FW: Further Response to Planning Application 3/2021/0275 Land Behind The Dog Inn Market Place Longridge PR3 3RR

Subject: Further Response to Planning Application 3/2021/0275 Land Behind The Dog Inn Market Place Longridge PR3 3RR

Planning Application
Plots 7 & 8. Plan

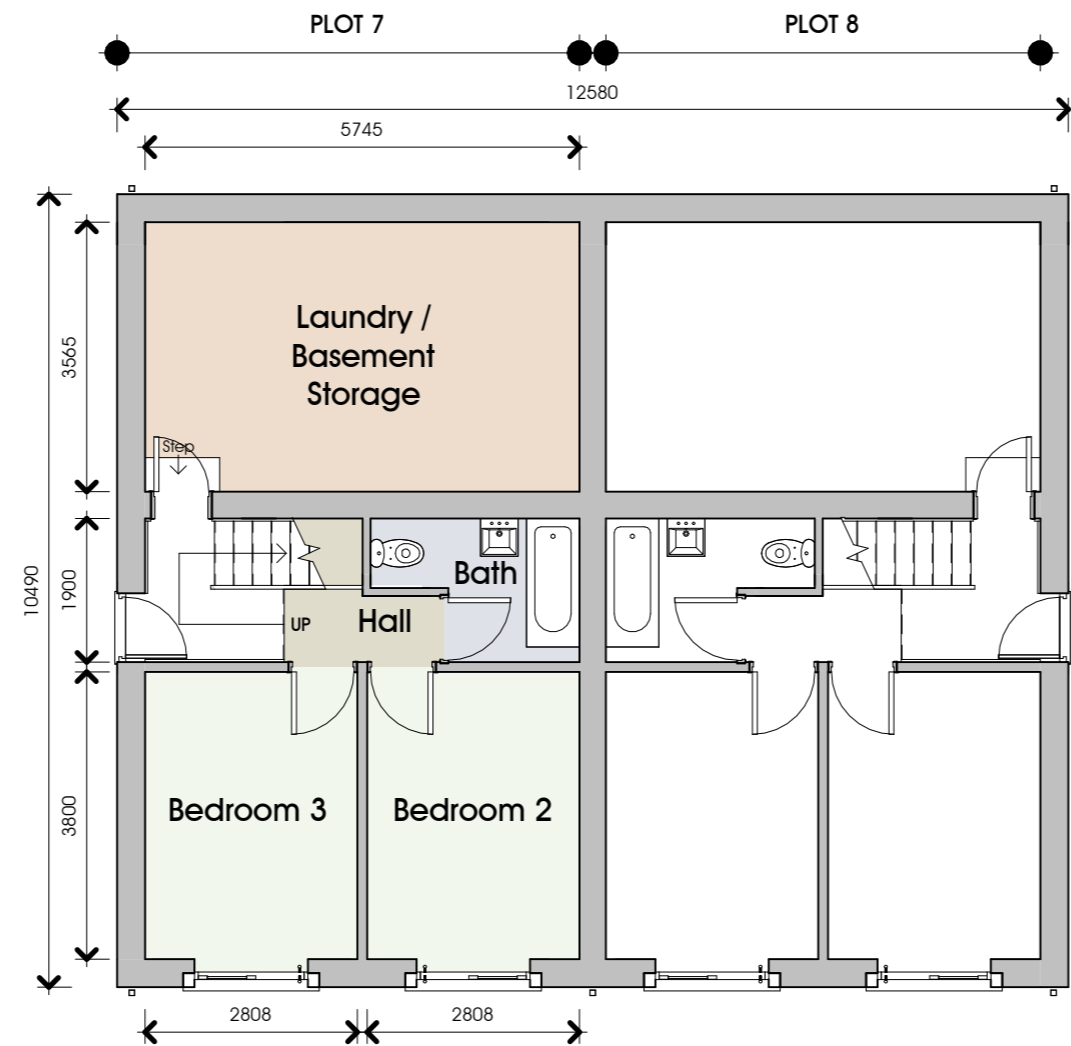
Although the revised plans show removal of dormers, there will still be 3 floors of windows facing Darwen Close which is at a much lower level than the development.

Plots 7 and 8 have the living accommodation at first floor height which will be looking directly into the rear of the properties on Darwen Close. We feel that any 2nd floor windows should not be facing Darwen Close.

Plot 8 is still less than 2 metres [REDACTED] will have a very detrimental effect of [REDACTED]
[REDACTED] As the plans now have 2 properties instead of 3, it would be less intrusive if the properties were moved further away from the eastern boundary.

Plot 7 and 8 are the highest point of the proposed development and plot 8 windows are approximately [REDACTED]
[REDACTED]

If Plot 8 was moved [REDACTED] it would make it possible to have soft landscaping at the eastern boundary which would help the drainage situation.

Proposed Site Plan
1 : 200
0 1 5 10m

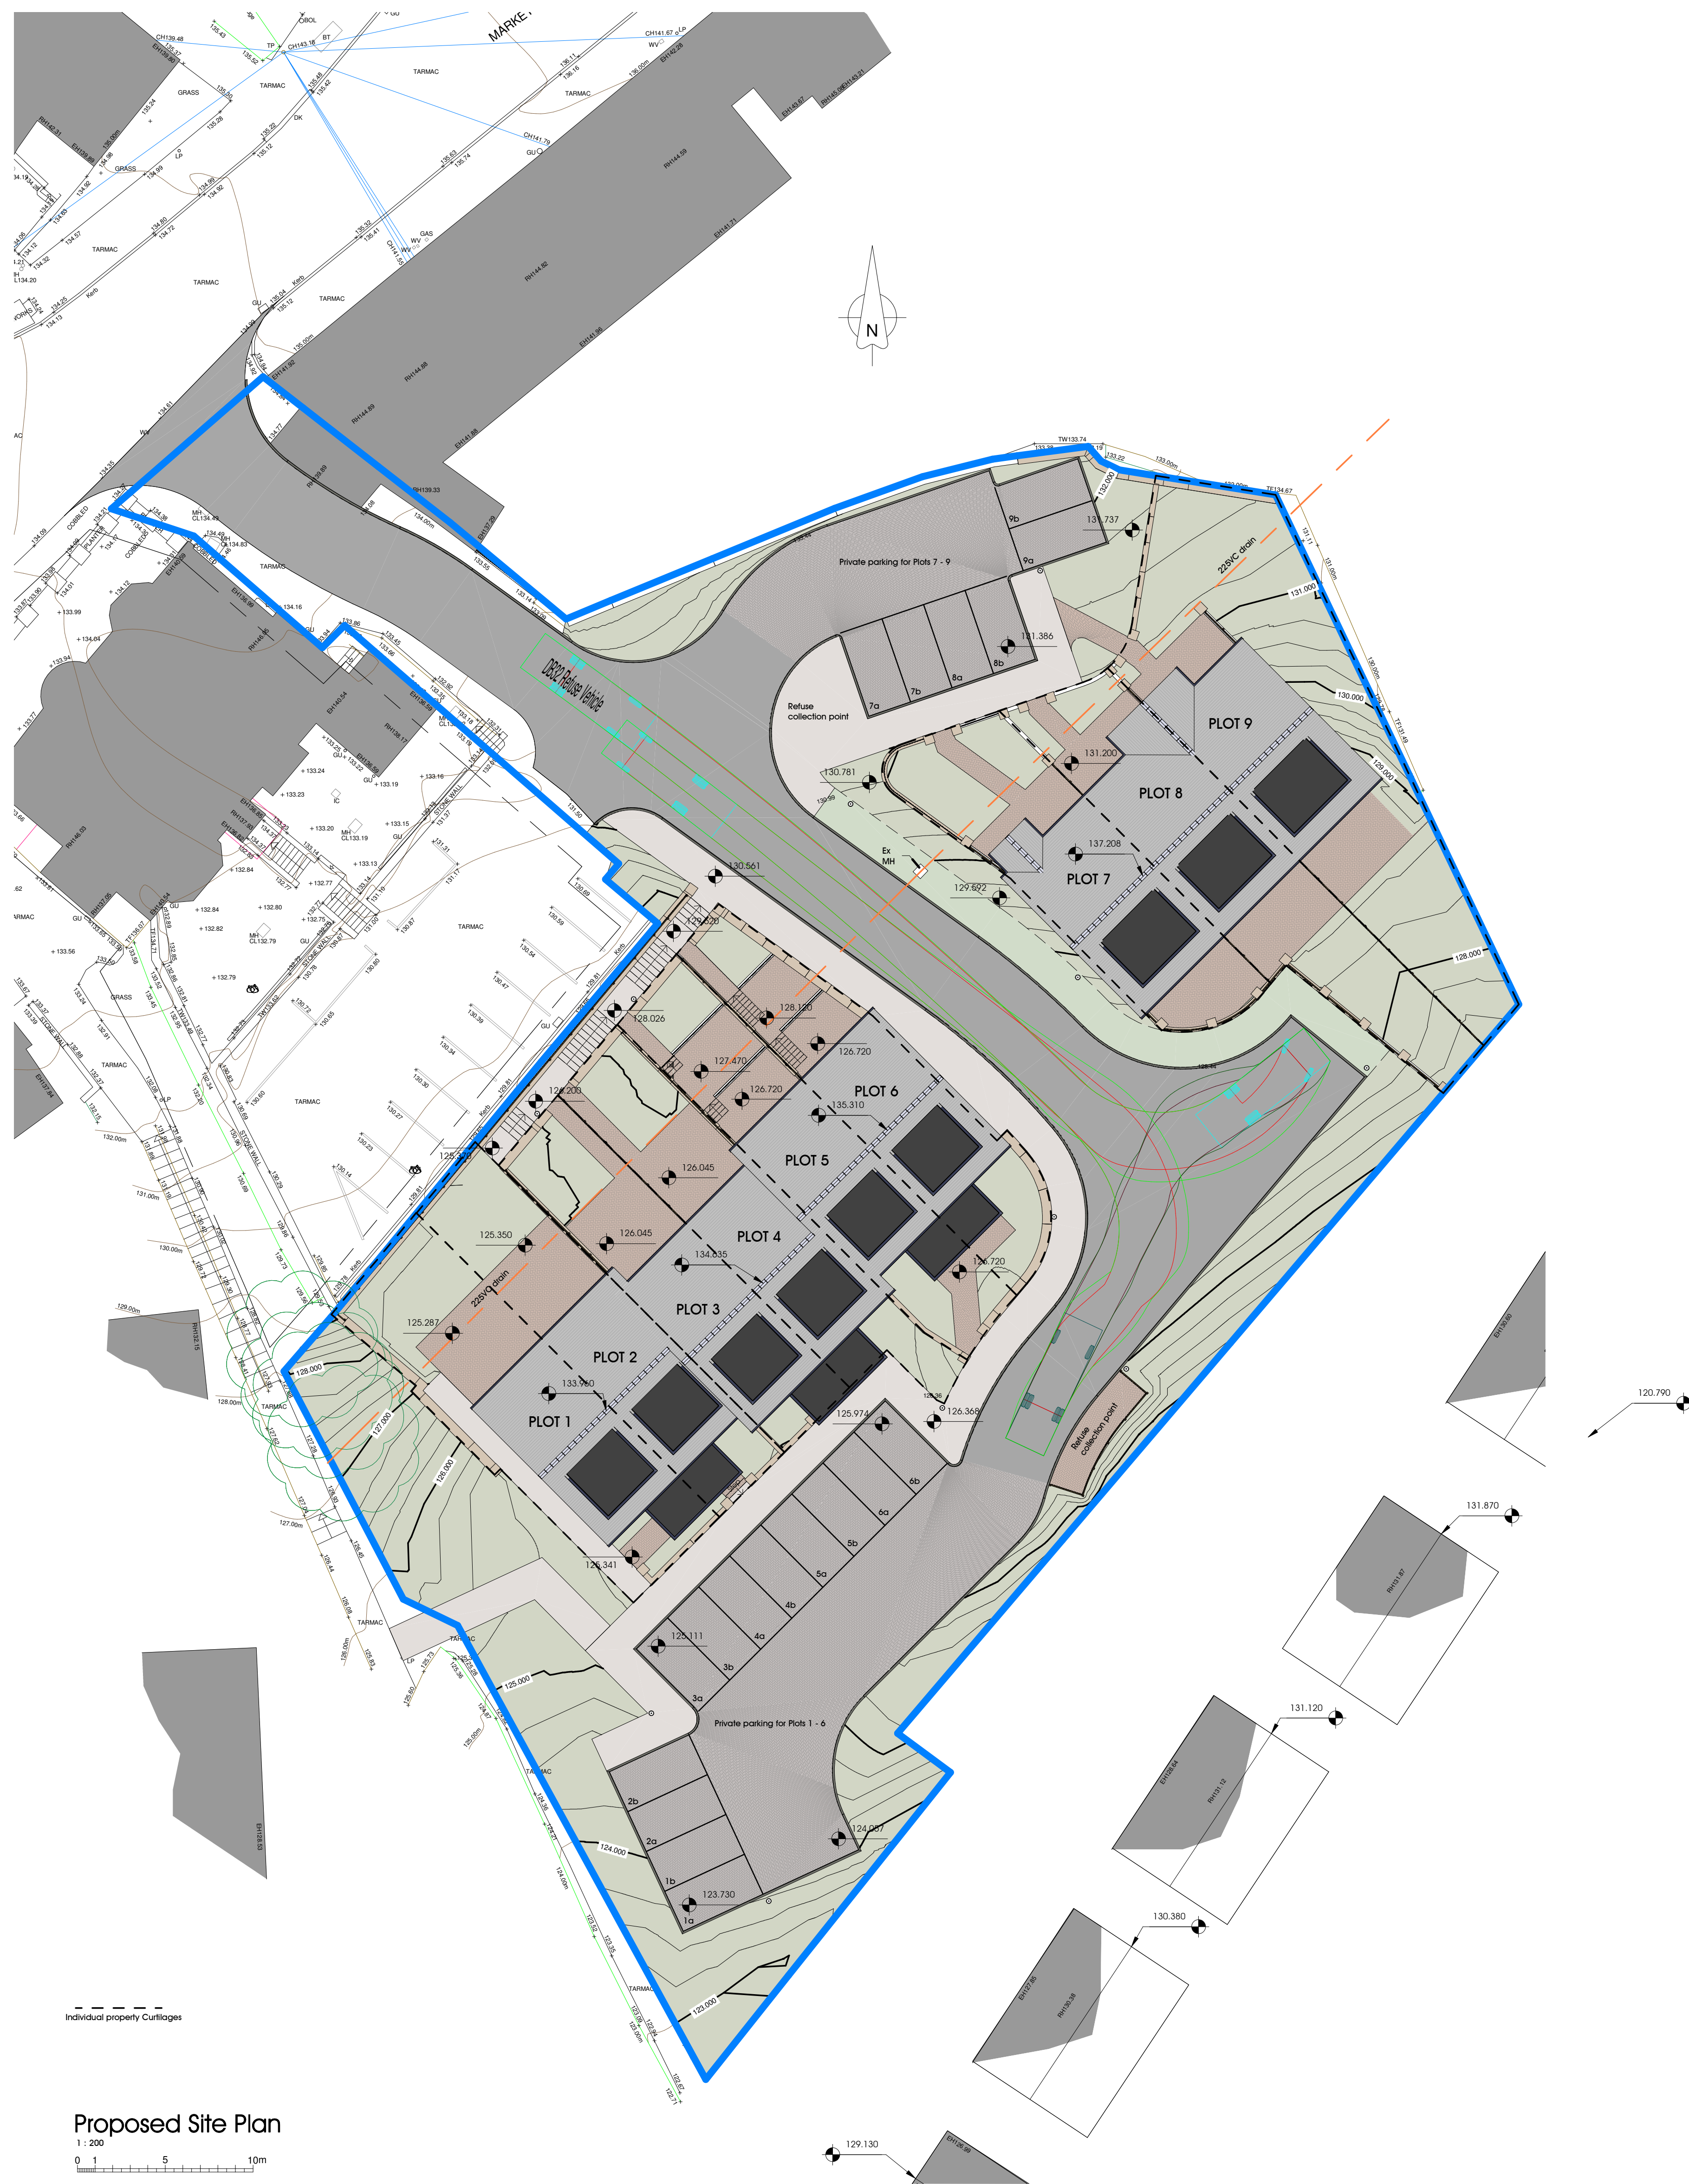
The mass of hardcore already put down on the site has already [REDACTED] susceptible to waterlogging and ground saturation. All the proposed hard landscaping will make the situation worse for all the adjoining properties on Darwen Close.

We feel that the proposed soakaway would not be adequate.

The G3 hedging should be retained as stated on plan. It is imperative that the tree roots are protected. Any new boundary fencing along the eastern boundary which is adjoining our land for its full length should be of substantial height for security and privacy.
